Lighting Plan_V1.pdf Markup Summary

Drawing Title		Reference Drawings	
Mfg.		M.F.	
Dwg. No.		Revision	
No.	Date	Dwn.	Appd.
7			
6			
5			
4			
3			
2			
1			
FOX RUN SUBSTATION 1157/69712.47KV LIGHTING PLAN TRI-STATE GENERATION & TRANSMISSION ASSOCIATION, INCORPORATED UPDATED BY: REVUL 4/27/22 9:28 AM Contact: D485			
TRI-STATE Generation and Transmission Association, Inc. A Touchstone Energy Cooperative 1100 W. 116th Ave. P.O. Box 33695 Denver, Colorado 80233 303-452-6111 DATE: As Proposed / Rev. Substation Light Planning			
Dwn:	Date:		
KGU	01-13-22		
Appd:	Date:		
KGU	04-05-22		
Light Plan

Polar LDC

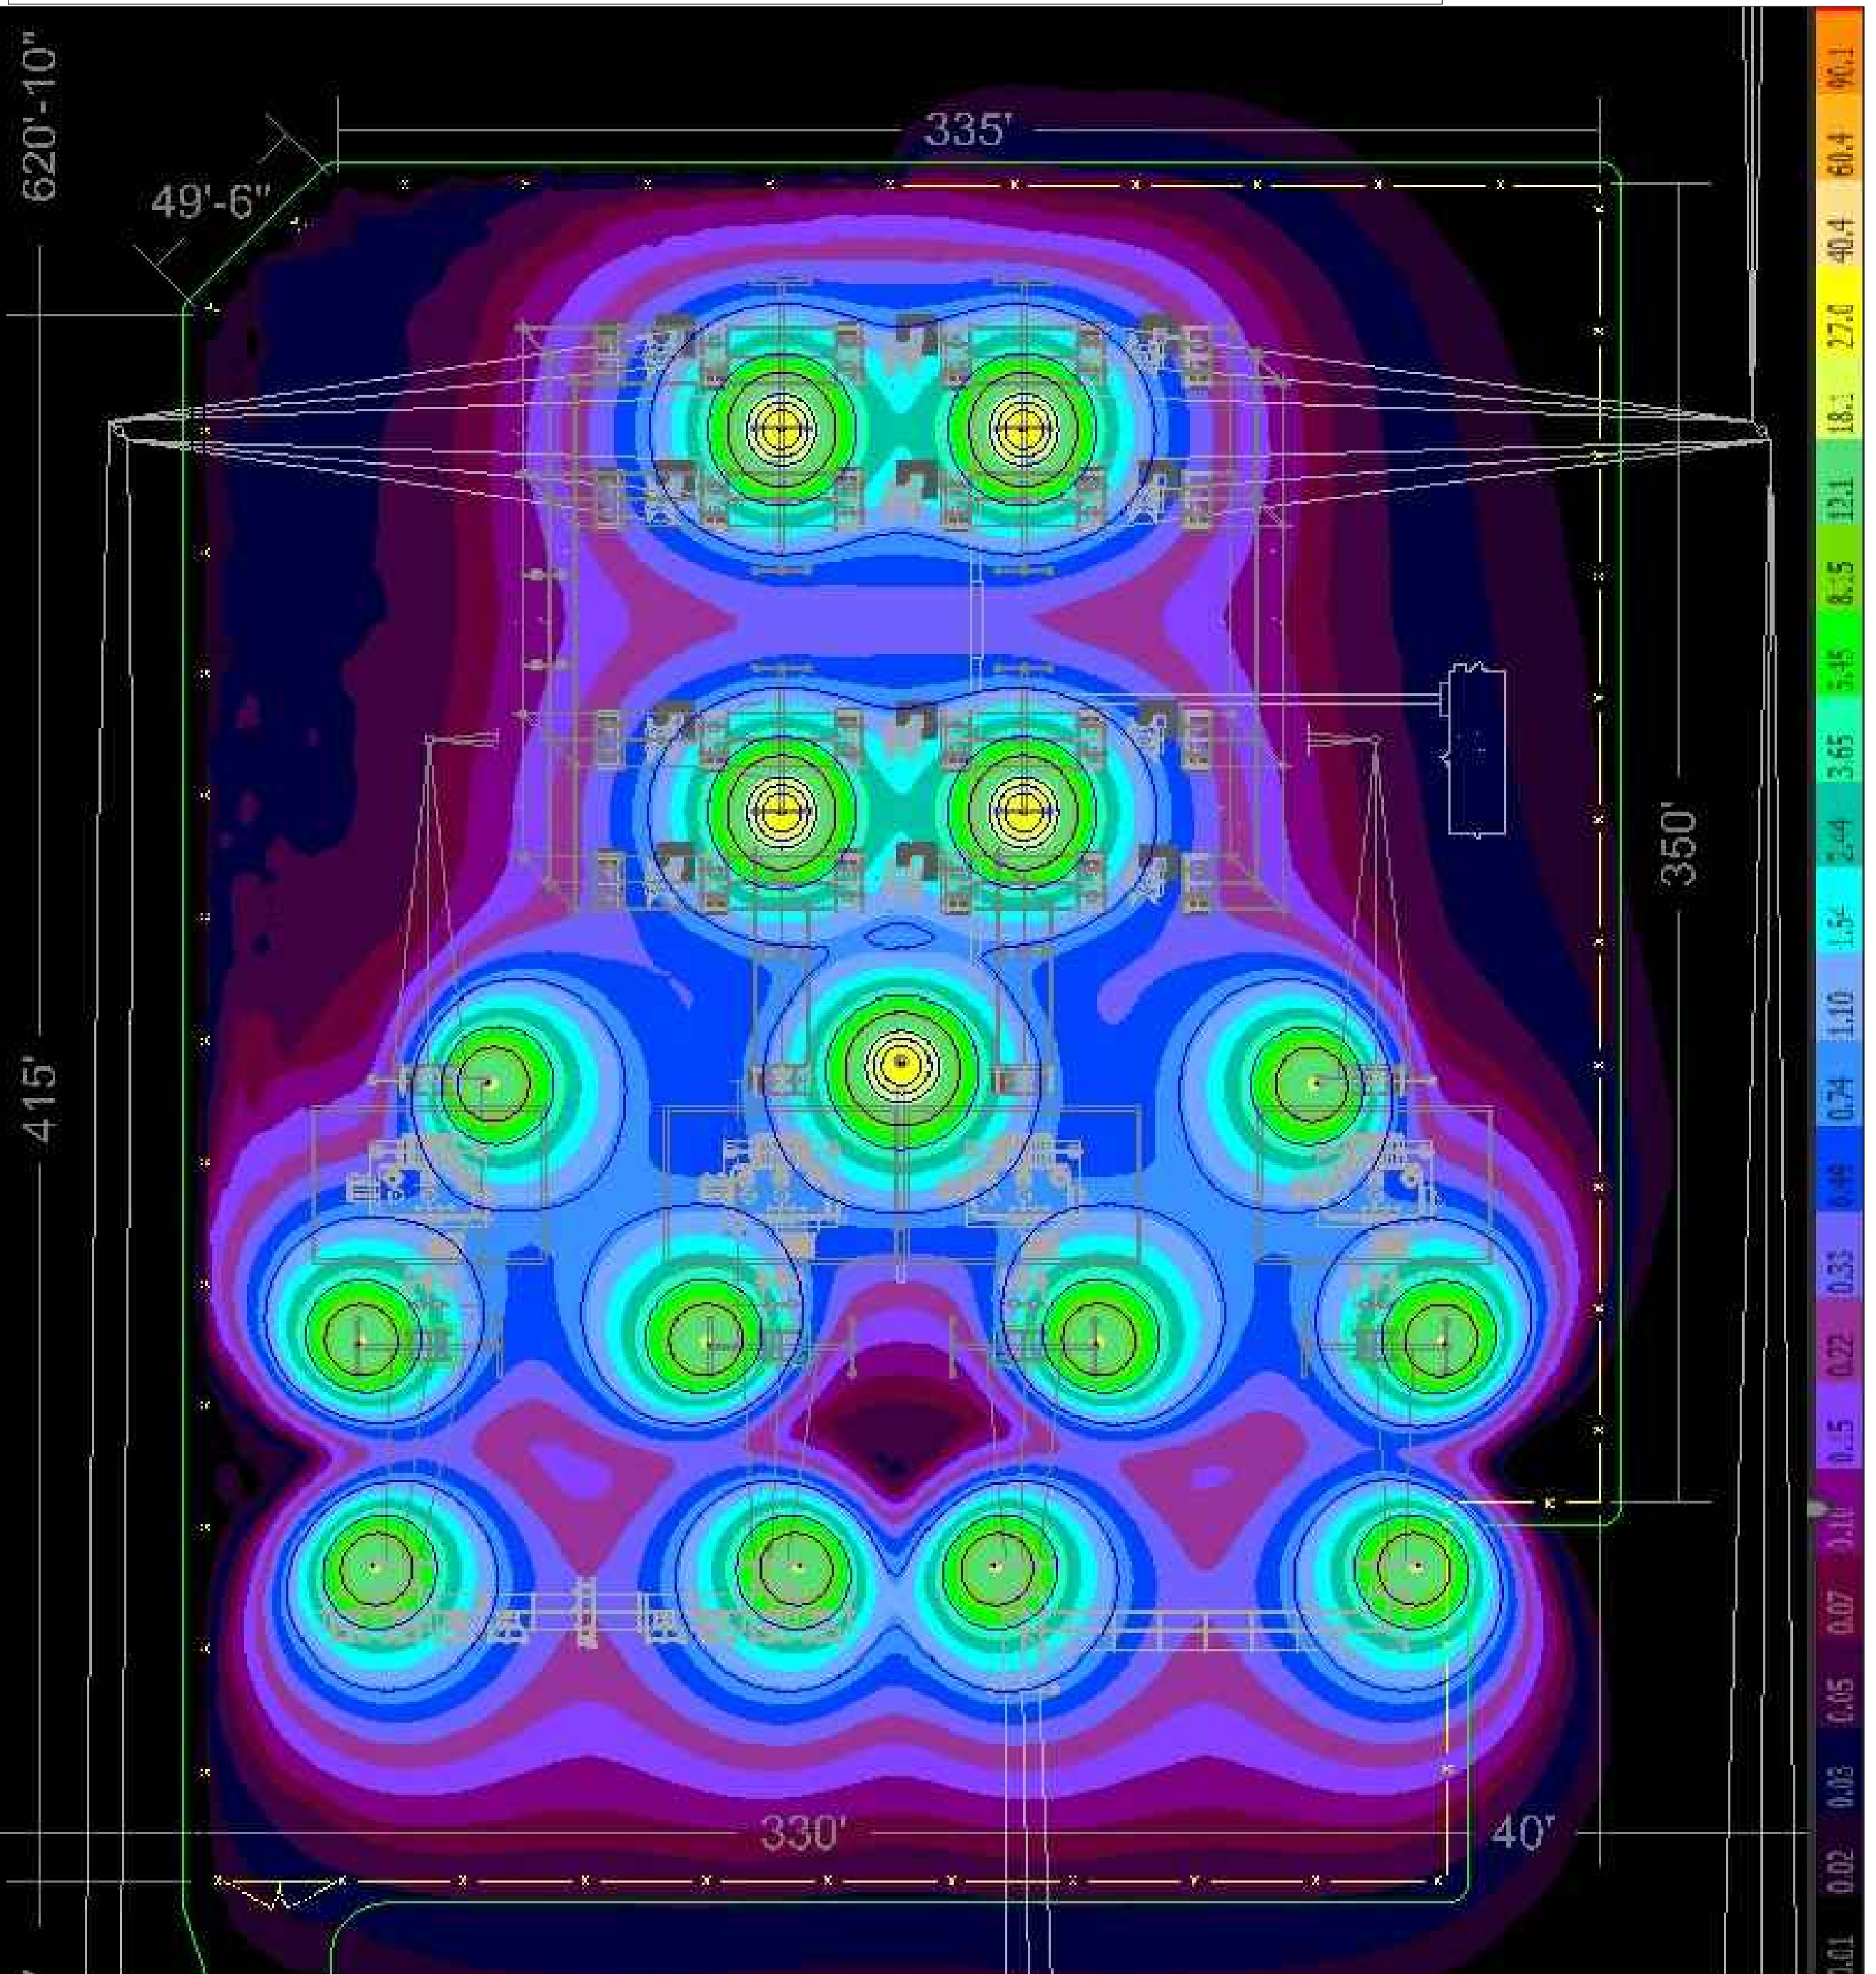
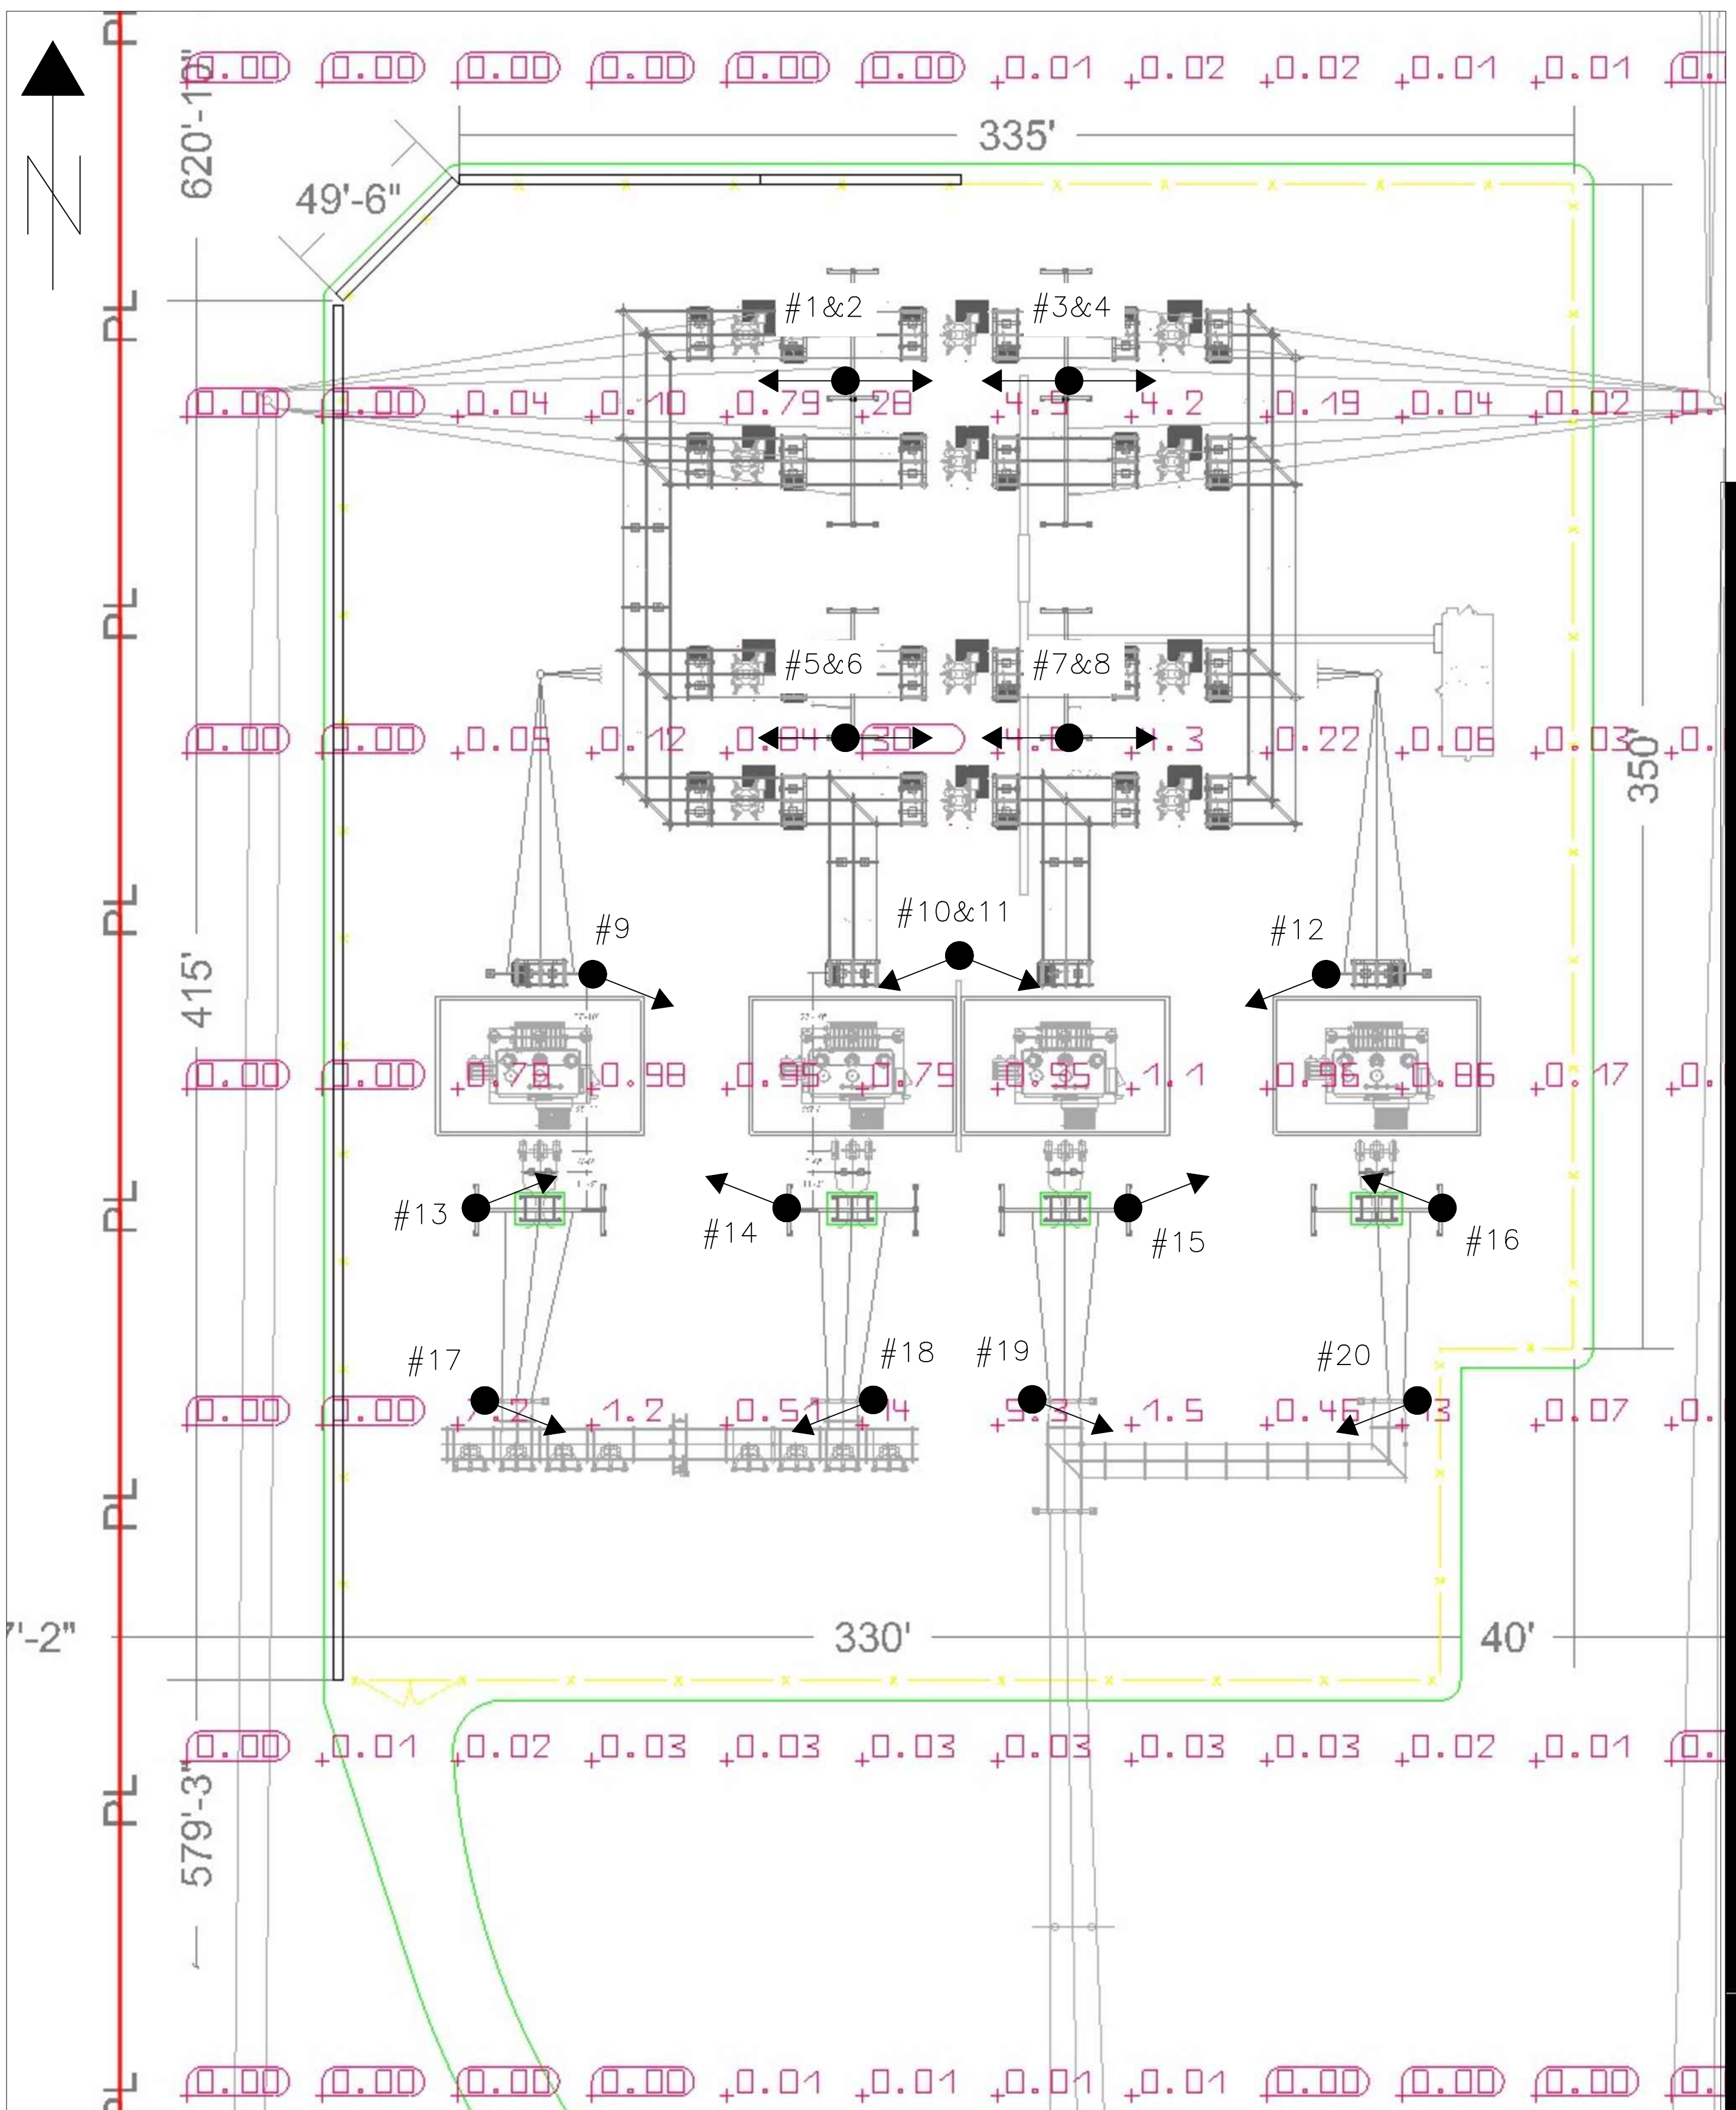
Show location and of all proposed illuminating devices

Please use a color that is legible; black or blue

Show all property lines and neighboring zoning.

Show the building footprint for all structures depicted and labeled, if any are proposed.

Add date, north arrow and graphical scale.
